Subject: RE: Planning Decision on EP/93/21/HH : 17 Selborne Way

Scale: 1:100
Paper: A3
Date: April 2021
Drg No.: SBS/697/19C

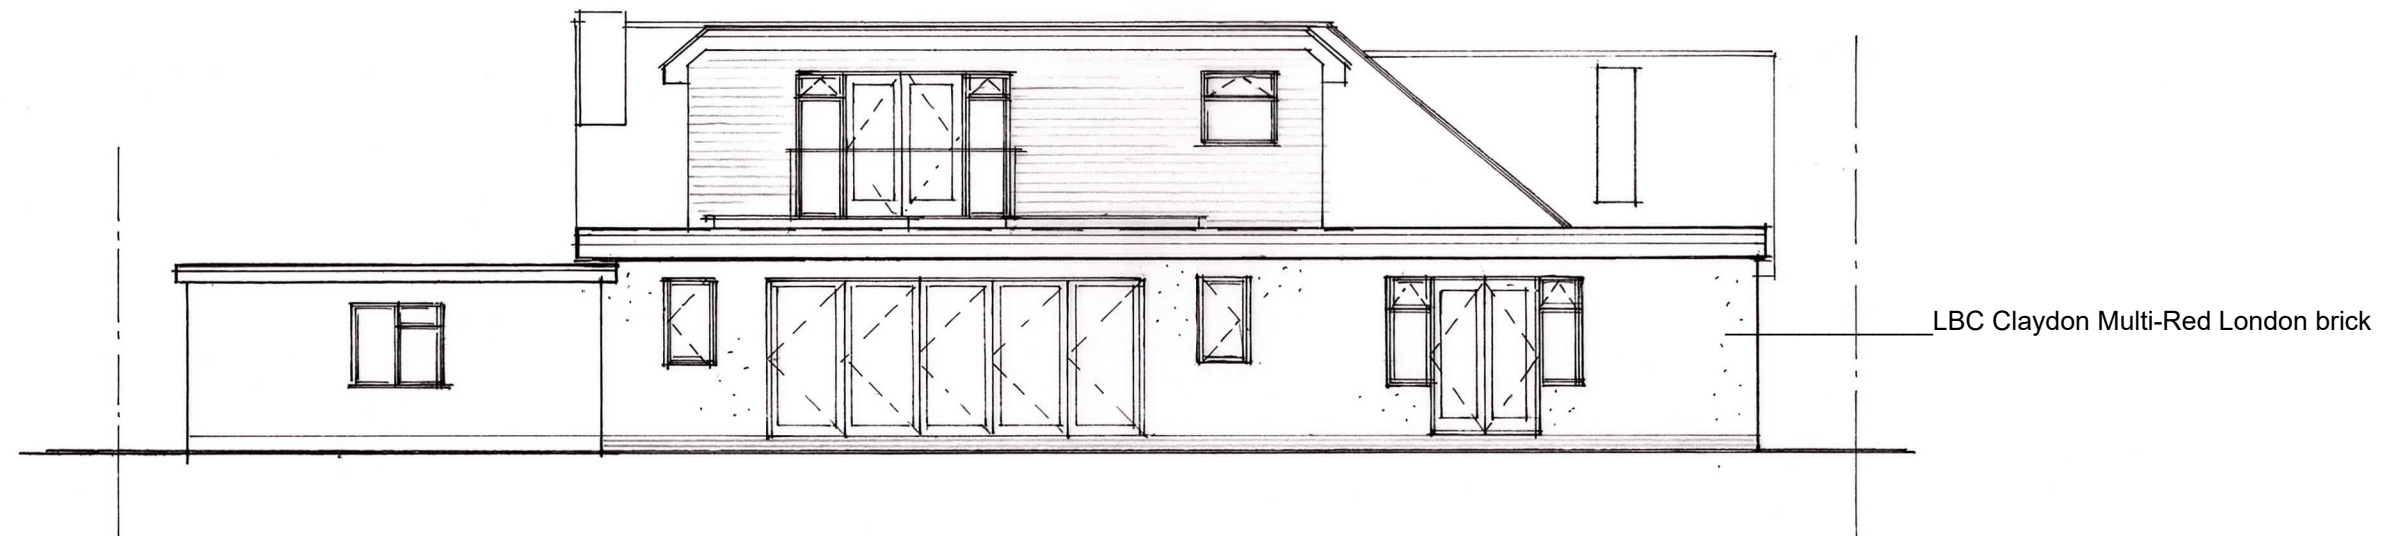
Condition 3 states "The materials and finishes of the external walls and roof of the building hereby permitted shall match in colour and texture those of the existing building". The existing walls are rendered and decorated and the applicant would like the extension walls to be built in face brickwork (LBC Claydon Multi-Red London brick) as stated on drawing no. SBS/697/19C.

Can you confirm Condition 3 does not apply to the external walls of the extension and these can be built with face brickwork in accordance with the approved drawings?

That's fine as you suggest. A copy of this email will be placed on the file.
